Application for Removal or Variation of a Condition following Grant of Planning Permission or Listed Building Consent

21/02020/PFUL3 (PP-10204833)

The drawings that were originally sent should have stated the windows to be openable however was mistakenly missed out and submitted in error. The correct drawings have been attached below. Refer to drawing: Home_NG6_7AY - Sheet - B-004 - SECTION & DETAIL DRAWINGS - REV A

Scale	As indicated	Drawn By	N.N
Drawing No.	B-004	Date	01.10.21
Client	Mr. & Mrs. Naushahi		
Project	SINGLE REAR ORANGERY		
Drawing	SECTION & DETAIL DRAWINGS		
Site Address	2 Borman Close, Hemphill Vale, Nottingham, NG6 7AY

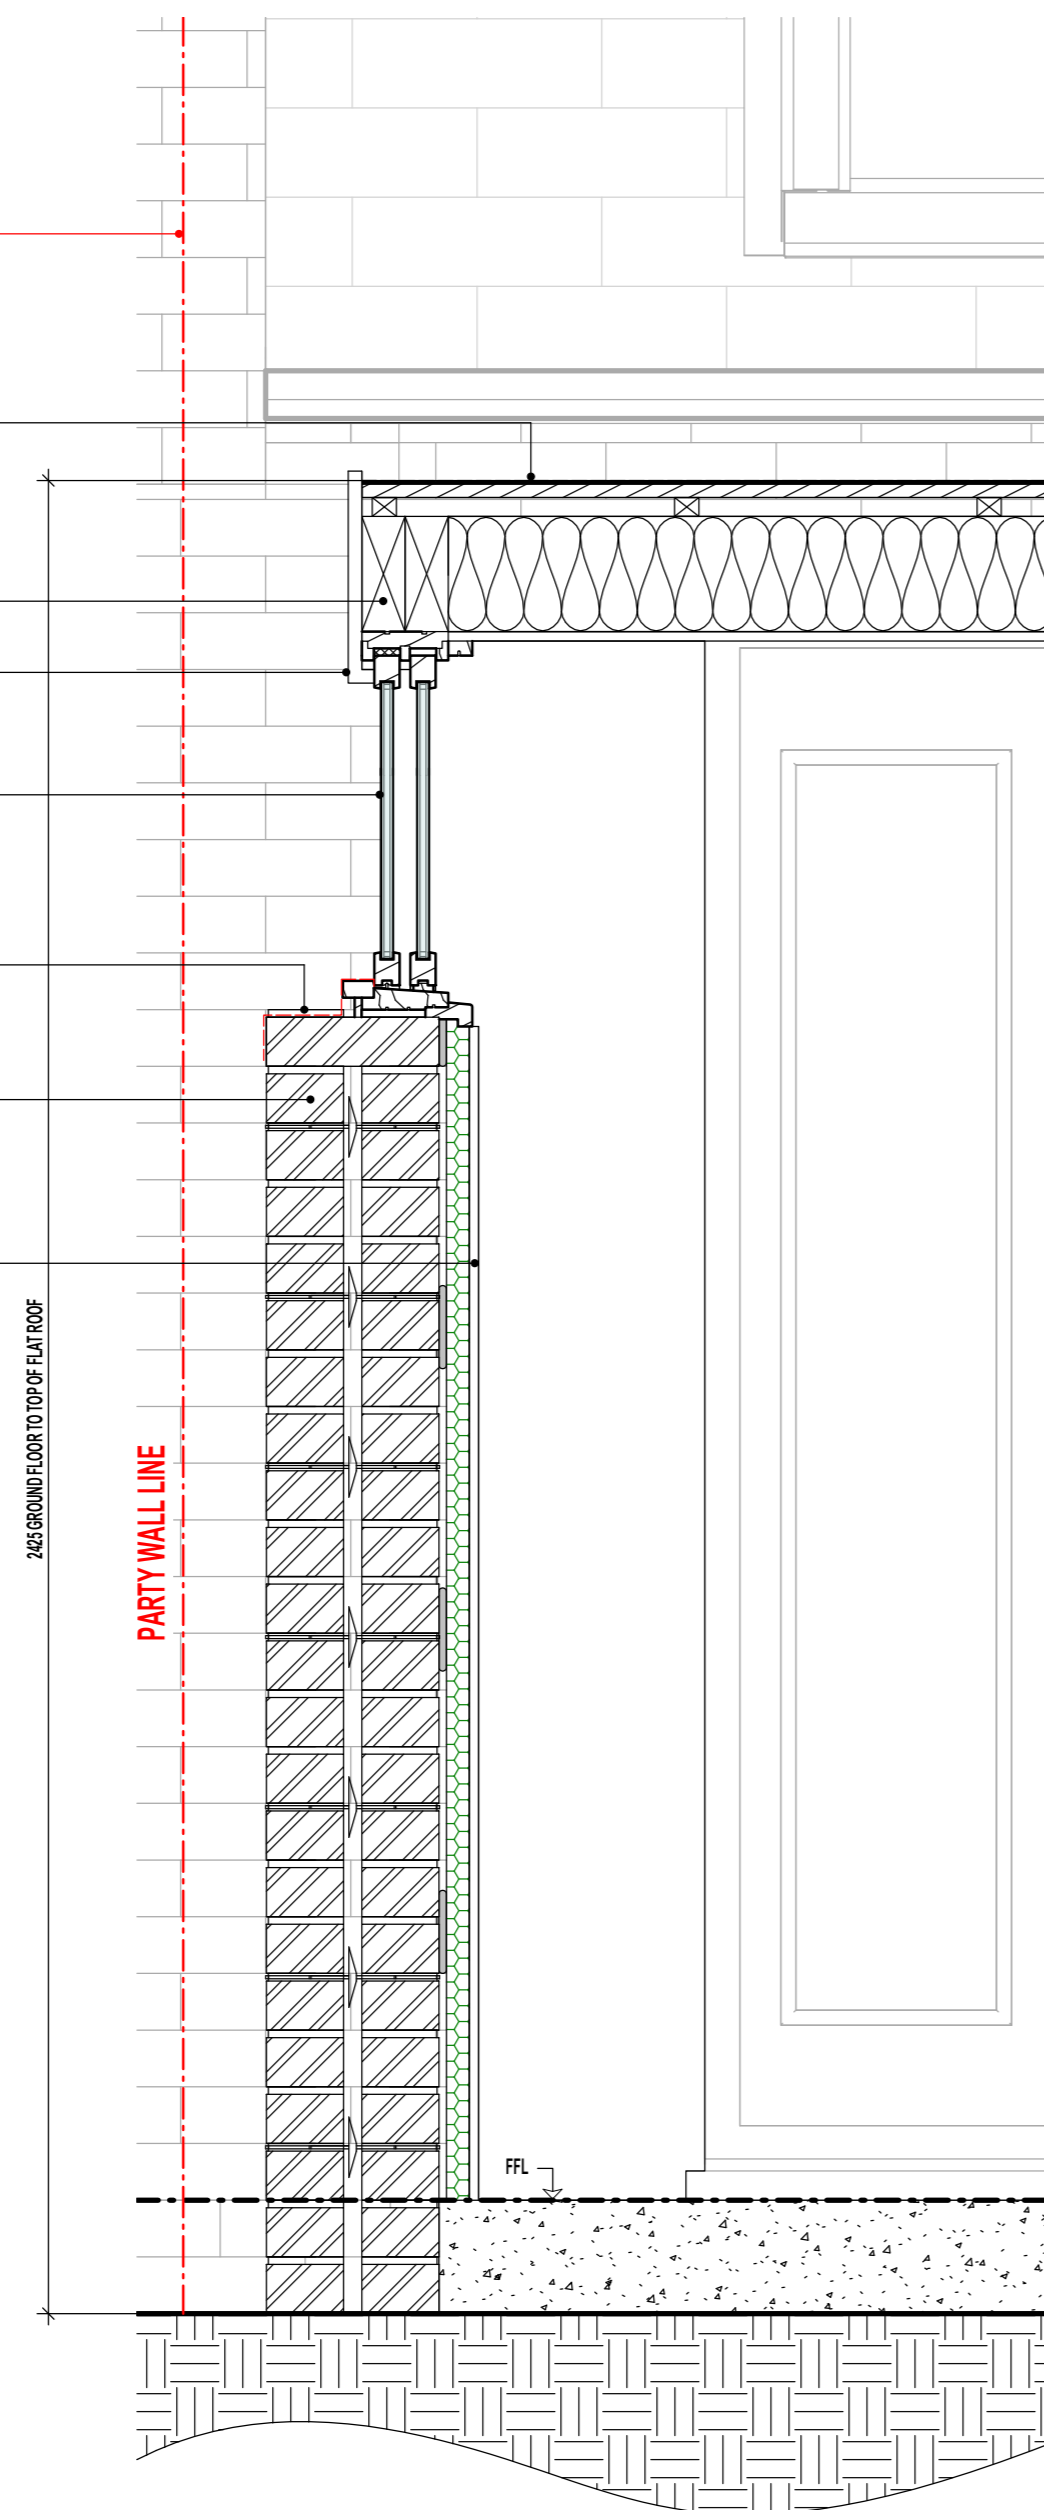
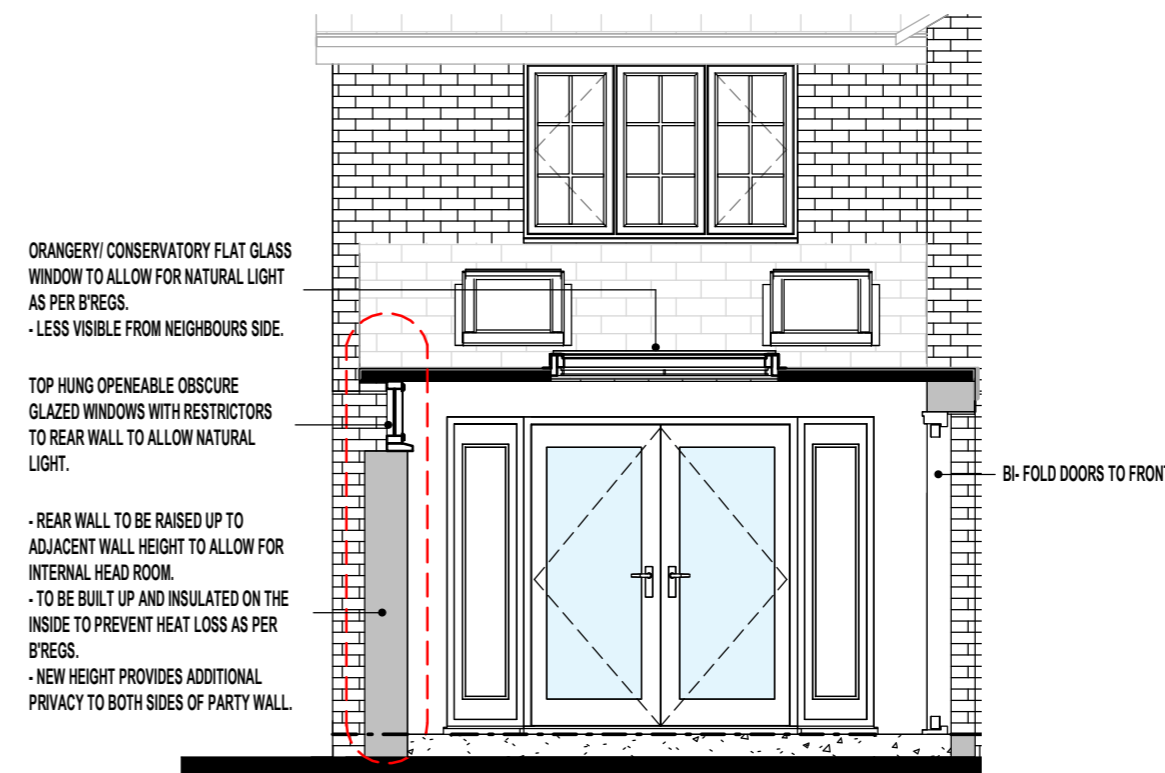
We wish the second part of the condition (non openable windows) to be changed as it prevents us from opening windows, complying with building regulations, and it prevents us our rights of cross ventilation and imposes serious health risks such as black mould if the room isn't properly ventilated. We are unable to open the windows during the hot summer months.

To comply with building regulations, any new habitable room requires adequate ventilation for general health reasons. The type of ventilation required is called 'Purge' and this is achieved by opening a window. The opening should have a typical area of at least 1/20th of the floor area of the room served. By design and functionality, this is the only place for our windows to be located. To comply with the latest regulations Part O (Overheating mitigation strategies), measures such as openable windows should be provided to prevent overheating problems.

- The windows are currently built at high level (above head space) as per the drawings and are top hung.
- The windows are obscure glazed and neither ourselves nor our neighbours are able to see in or out of the orangery. (Pictures were provided to Martin Pool (Area planning manager).
- The windows are fitted with restrictors and only open into our air space within our boundary line as per the drawings.
- The windows would generally be open during the warmer summer months and will generally remain shut during the colder winter months.

As you can see this has a minimal effect and and little to no impact on the amenity of our neighbours. The windows do not open beyond the boundary line, they are obscure glazed, and they are top hung above headspace and have restrictors in place.

Please could you amend the condition to include for the windows to be openable for the reasons stated above.
